Recommendation Report for Planning Permission for Works or Extension to a Dwelling

REF NO: FP/250/21/HH

LOCATION: 11 Roundle Square Road
Felpham
PO22 8JX

PROPOSAL: Conversion of loft to habitable use including the installation of 2 x side dormers.

DRAWING	SCALE
PLANNING	1/100 @A
DATE: OCTOBER 2021	
DRAWN: T. Murray	
DRAWING: 21/75/3	REVISION:

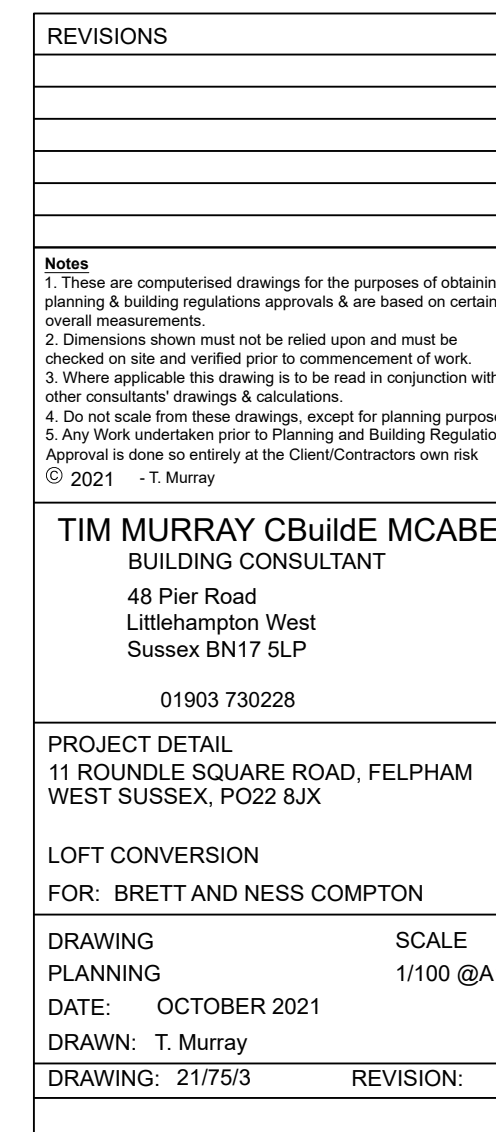
The dormers appear appropriate in scale to the size of the property, located below the ridge of the dwelling and stepped in slightly from the eaves.

The Arun Design Guide states 'Alterations to the roof profile should not detract from the character and appearance of the dwelling or wider area in any case, this can be achieved through smaller scale dormer windows with pitched roofs.' Favours small scale dormer windows with pitched roofs over large, flat box-shaped designs'. The proposal conflicts with the design guide in that dormers have a flat roof.

Part of the roof rear slope will alter to form a gable end to enable the dormers to be constructed. The dormers will have a length of 4.6m, a height of 2.3m and a depth of 3.25m. This is set 0.75m below that of the ridge height.

There are no windows proposed to the eastern side of the dormer, this will ensure there is no direct overlooking upon the rear gardens of neighbouring properties to this elevation.

There will be 2 windows to the western side elevation serving a bedroom. One of these will be at high level to restrict views towards the garden of the neighbouring dwelling. The 2nd window due to its siting, when looking at a 45 degree angle is not considered to achieve views into the garden of No.9 and does not result in adverse overlooking. There will be 2 windows to the rear of the dormers. One of these will serve a bathroom and will be conditioned to be obscured. The rear facing window to the eastern side will provide some views over the gardens of neighbouring dwellings although due to the angle, this will not provide views direct into properties. There will also be 3 rooflights to ensure there is adequate natural light into the rooms which do not rise to overlooking.

- 3 The first floor window on the rear north western elevation of the dormer shall at all times be glazed with obscured glass.
